# Planning Inspectorate

## Application by Morgan Offshore Wind Limited and Morecambe Offshore Windfarm Limited for an Order Granting Development Consent for the Morgan and Morecambe Offshore Wind Farms Transmission Assets

### Issue Specific Hearing 1

Dates: 30 April 2025 to 1 May 2025

Swept Path Assessment
Indicative of 24 Axle Girder Frame Trailer
Constructed from OS Master Map Data
Scale 1:750

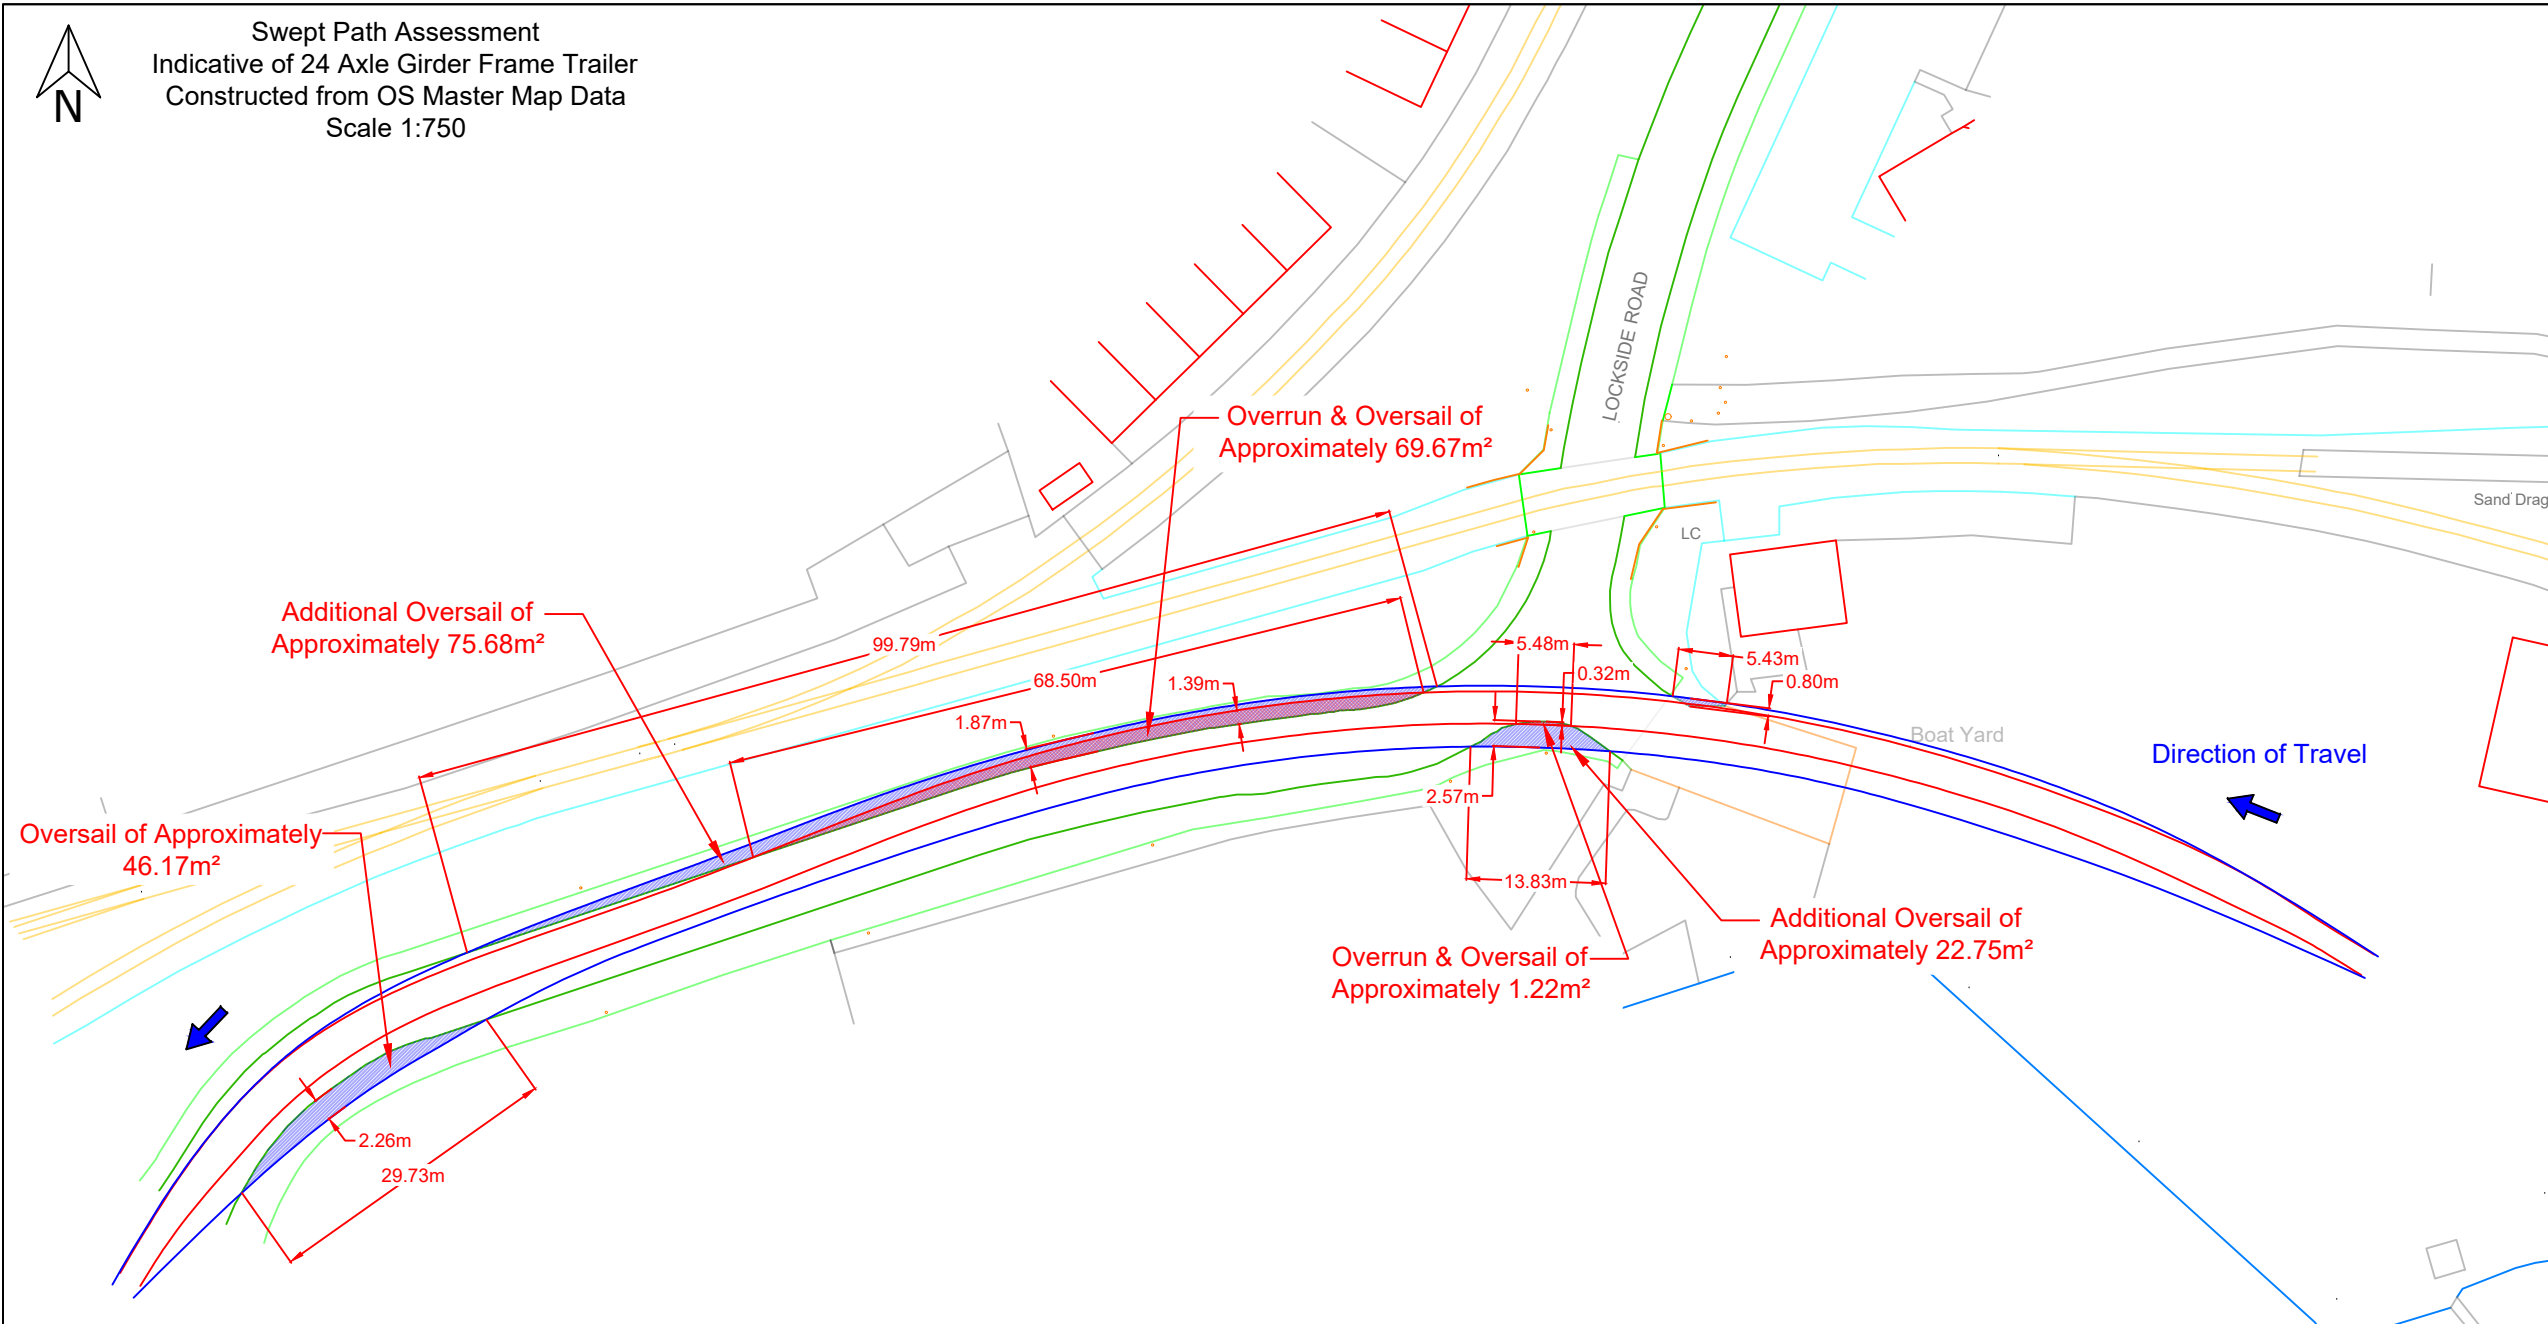
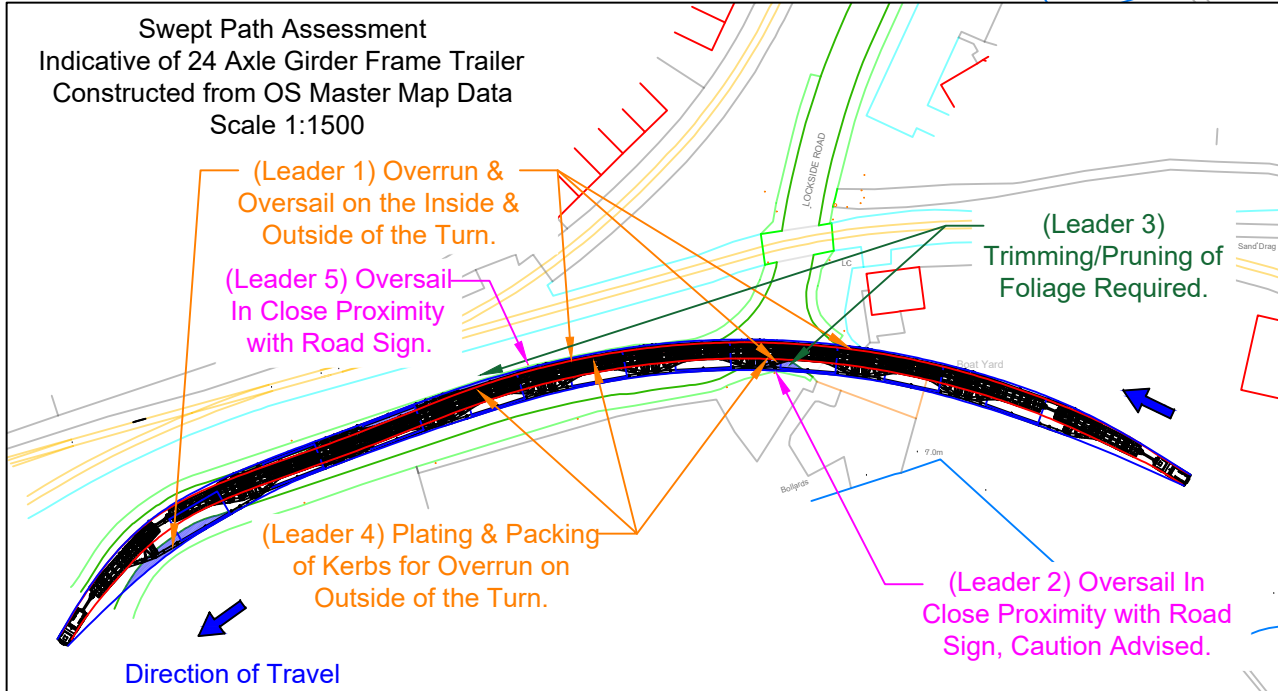
| 35. | Applicants                   | Provide an analysis relating to the Abnormal Indivisible Load swept path as an appendix to the Outline Construction Traffic Management Plan (APP-211).   | D2 |
